**Consultation Response from KC,
Lead Local Flood Authority**
2022/92081 Land at, Huddersfield Road/Leeds Road, Birstall, Batley, WF17 9AA
Demolition of existing buildings and erection of retail food store with associated parking and landscaping
Date Responded: 25/07/2022
Responding Officer: Martin Stephenson
Responding Ref: 0
Previous response by the LLFA

Documents reviewed by the LLFA:

- Document Ref: E20/7706, Surface Drainage Feasibility Calculations, dated May 2021
- Drawing Ref: E20/7706/01, Engineering Feasibility Plan, Rev C dated 10/06/2022

Title: Proposed Site Plan
Client: Wharfedale Ltd.

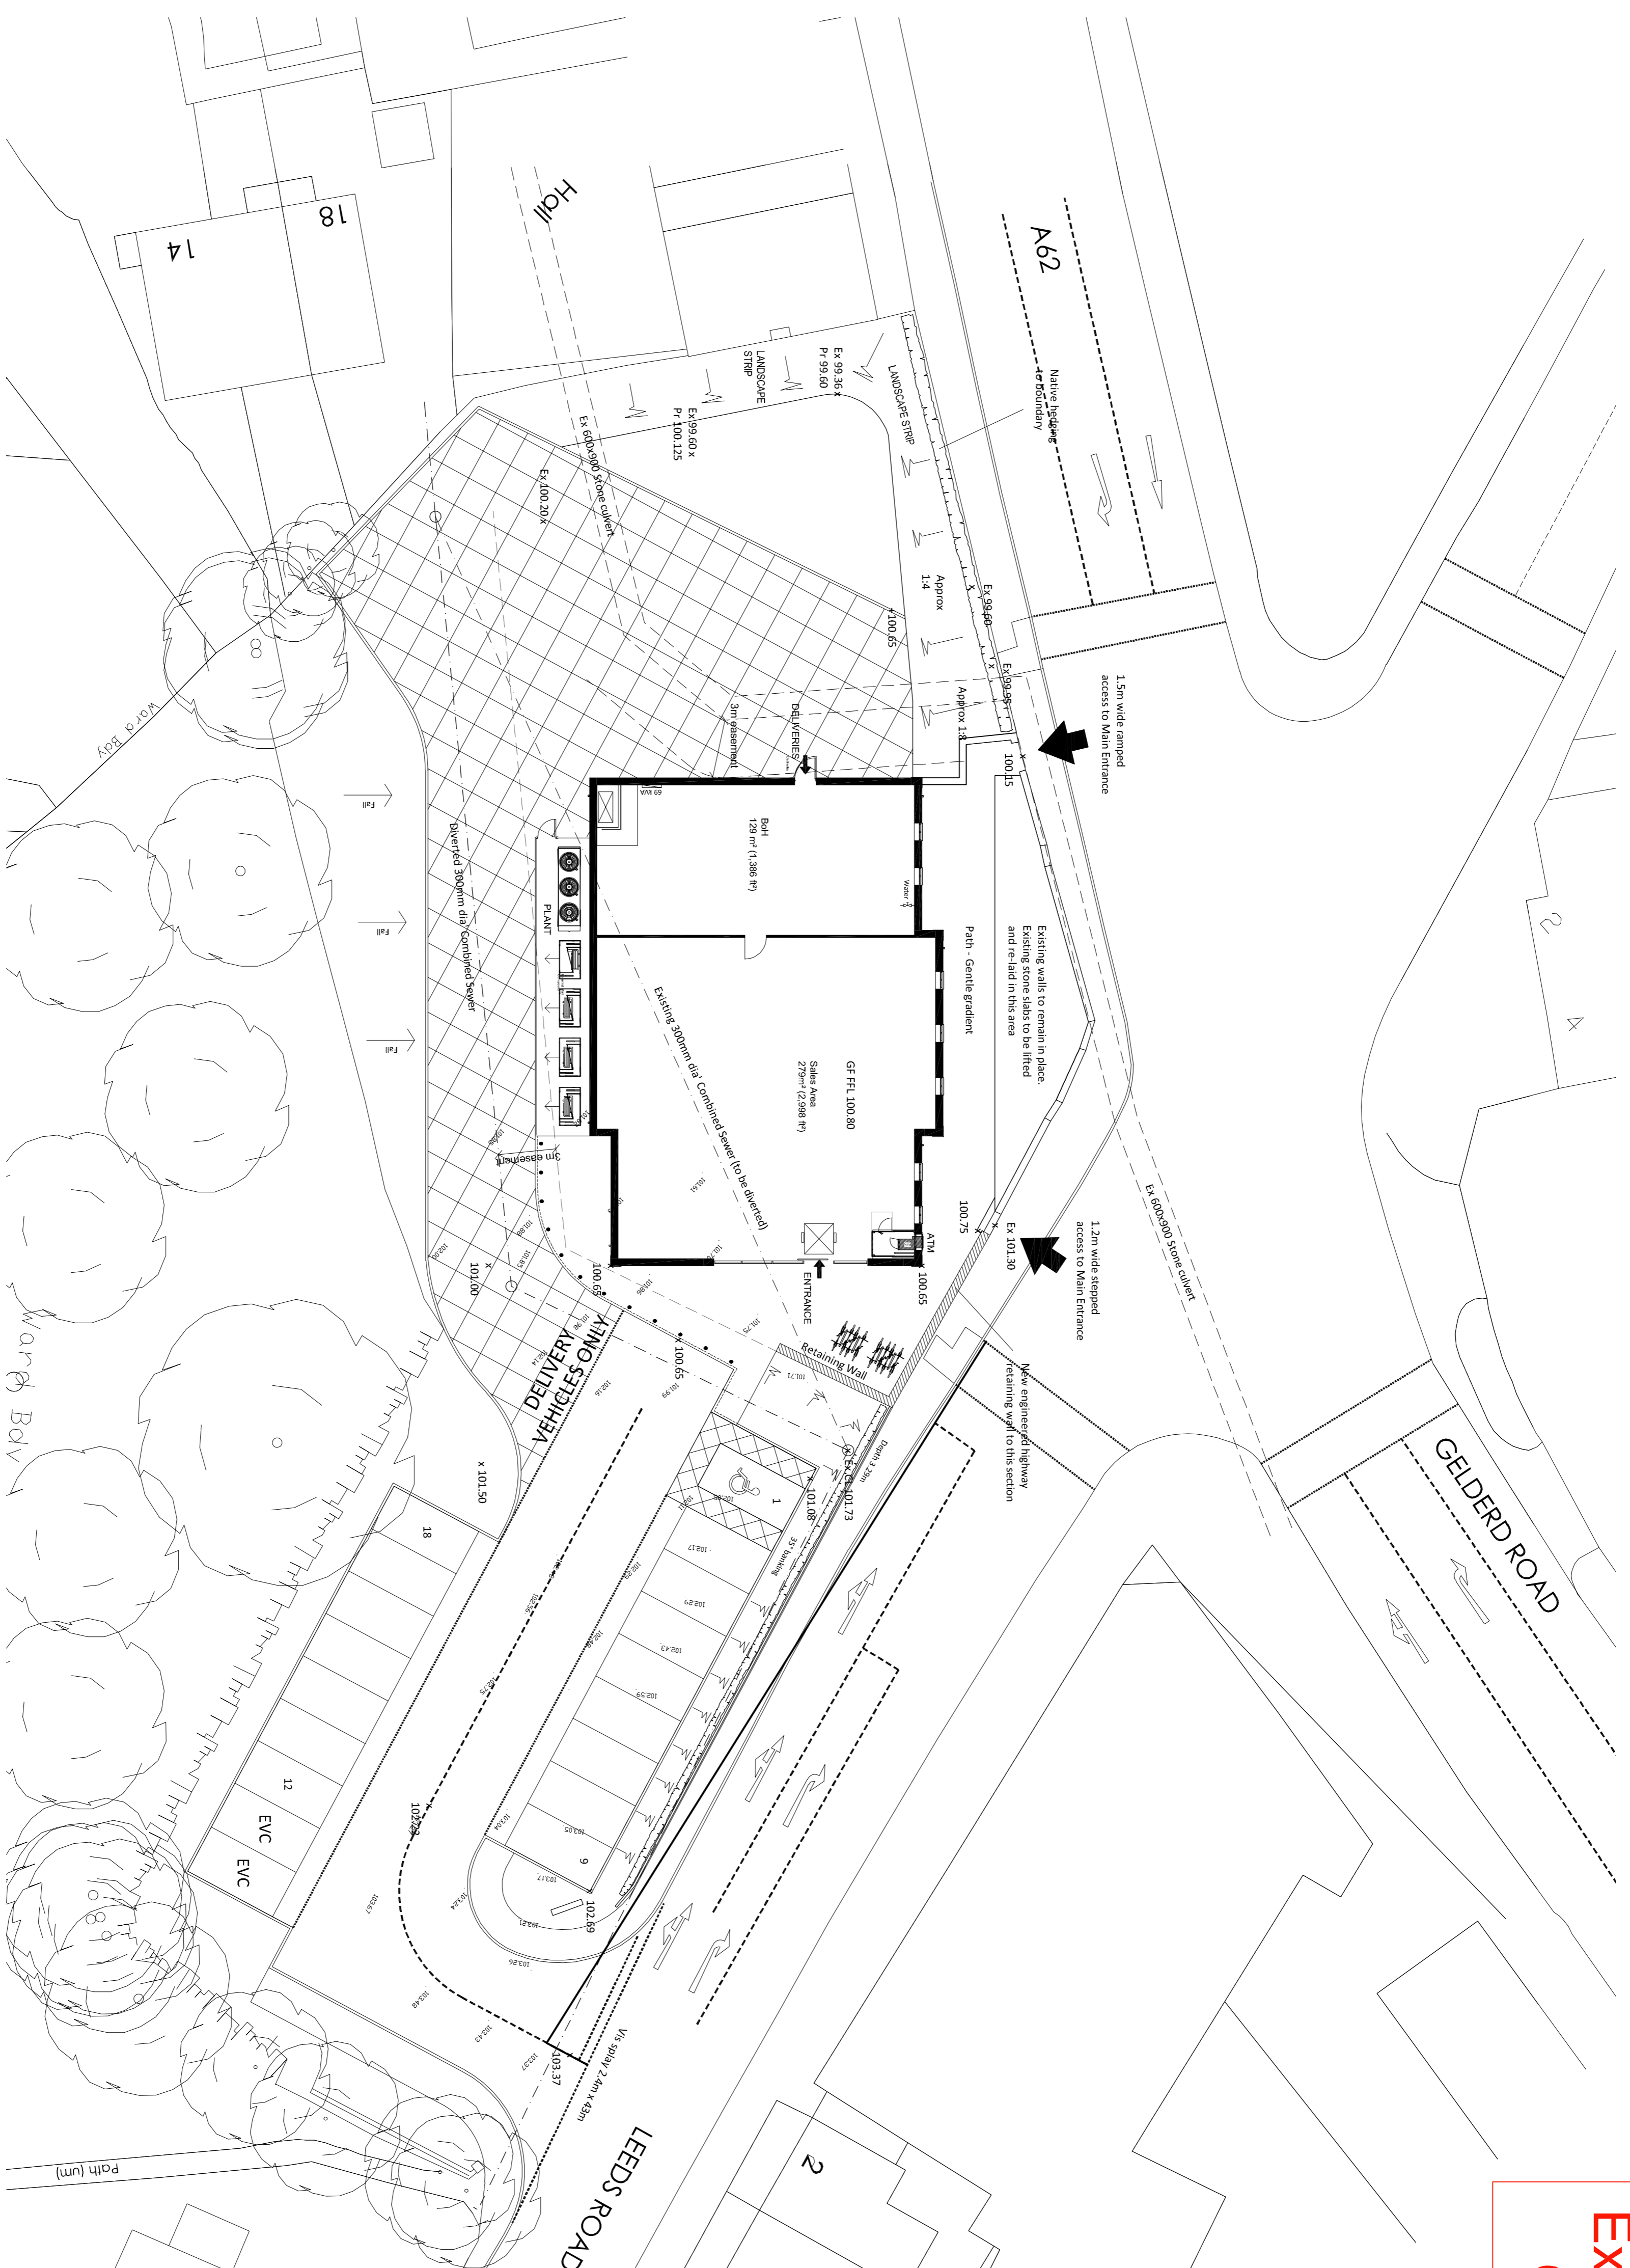
The drainage drawing (E20/7706/01) does not indicate that the required easement has been provided between the proposed building and the existing culvert.

Flood routing following an exceedance event or blockage should be indicated on plan and should show that no existing or proposed buildings within or outside the site will be at risk of flooding.
